CITY OF ALBUQUERQUE

August 22, 2012

**Re: ABQ Health Partners Primary and Urgent Care Facility Parking,
9101 Montgomery Boulevard NE, Traffic Circulation Layout
Architect's Stamp dated 07-09-12 (F20-D023)**

AS-101

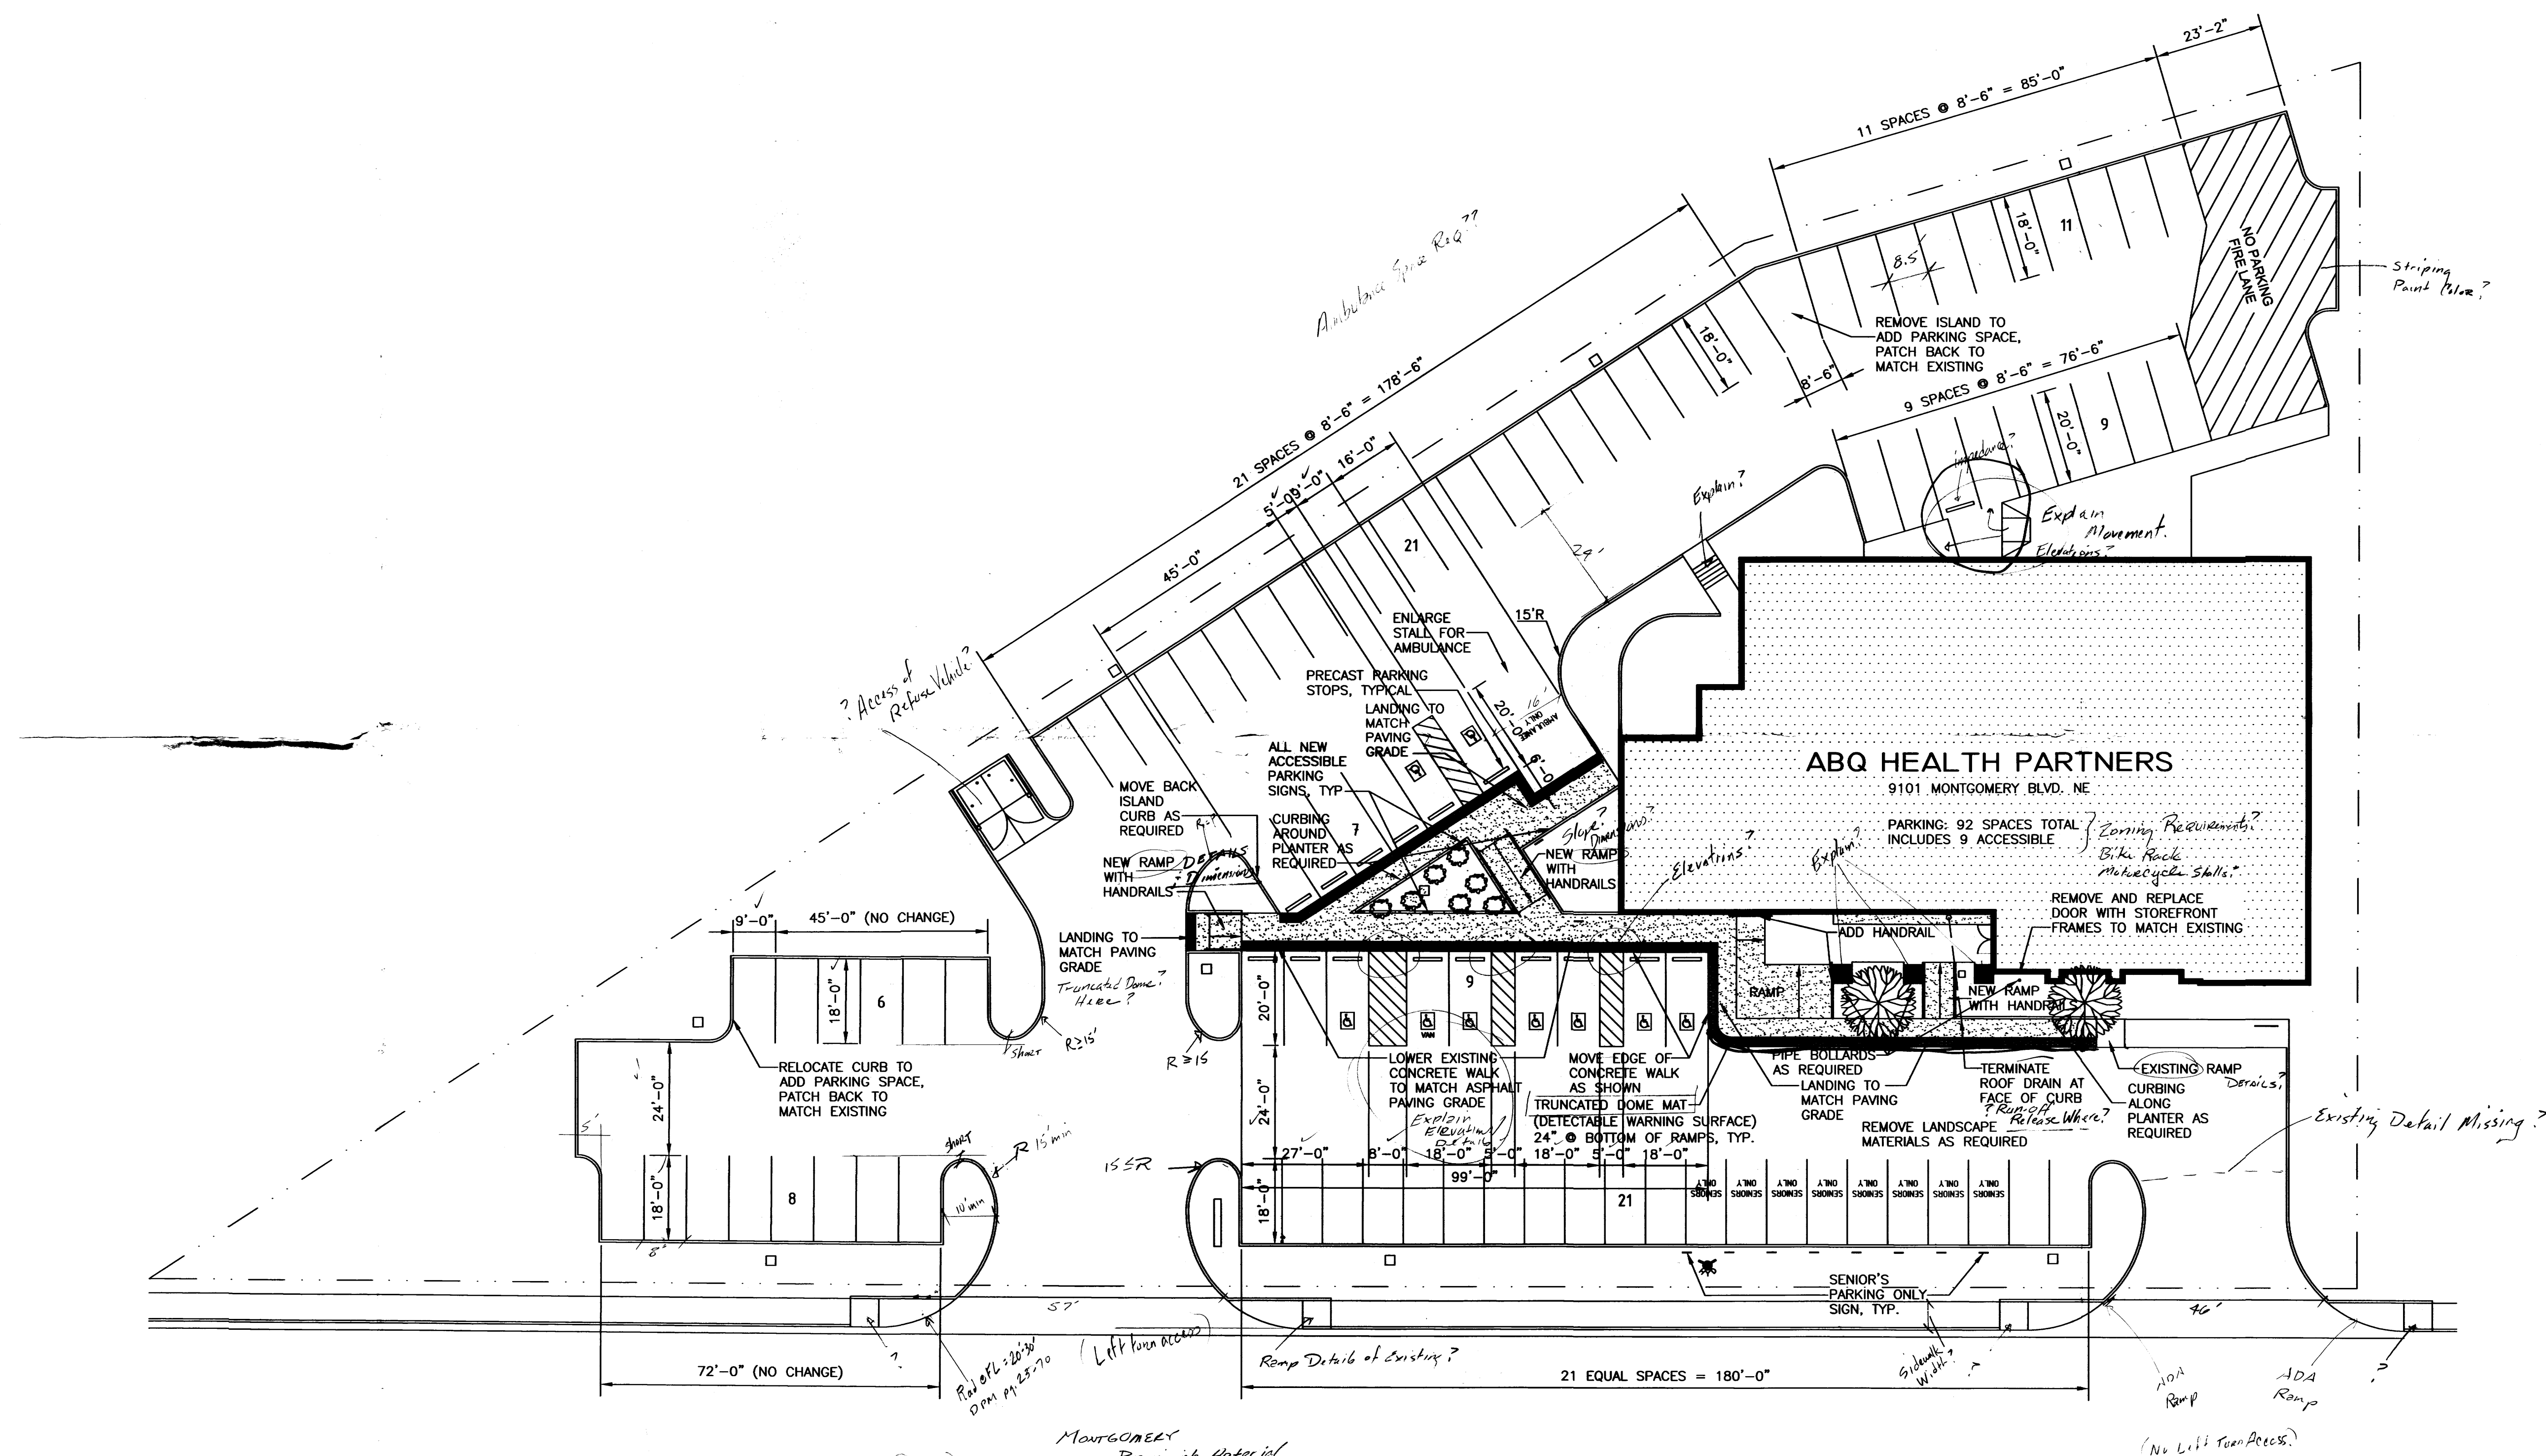
1. Please show a vicinity map.
2. Provide the legal description on the plan.
3. List the number of parking spaces required by the zoning code as well as the proposed number of parking spaces.
4. Provide a legend, defining all linetypes and hatching.
5. Per the *Development Process Manual*, Chapter 23, Section 7, Part A.6, "Curbing should be used to separate landscaping from parking areas and pedestrian ways." The proposed truncated dome mat south of the building does not appear to significantly separate the parking area from the pedestrian way.
6. It is unclear what is being proposed north of the building. Is this a drop off area?
7. The roof drain appears to be guiding drainage over the sidewalk; please clarify.
8. Define the maximum slope of the proposed ramps.
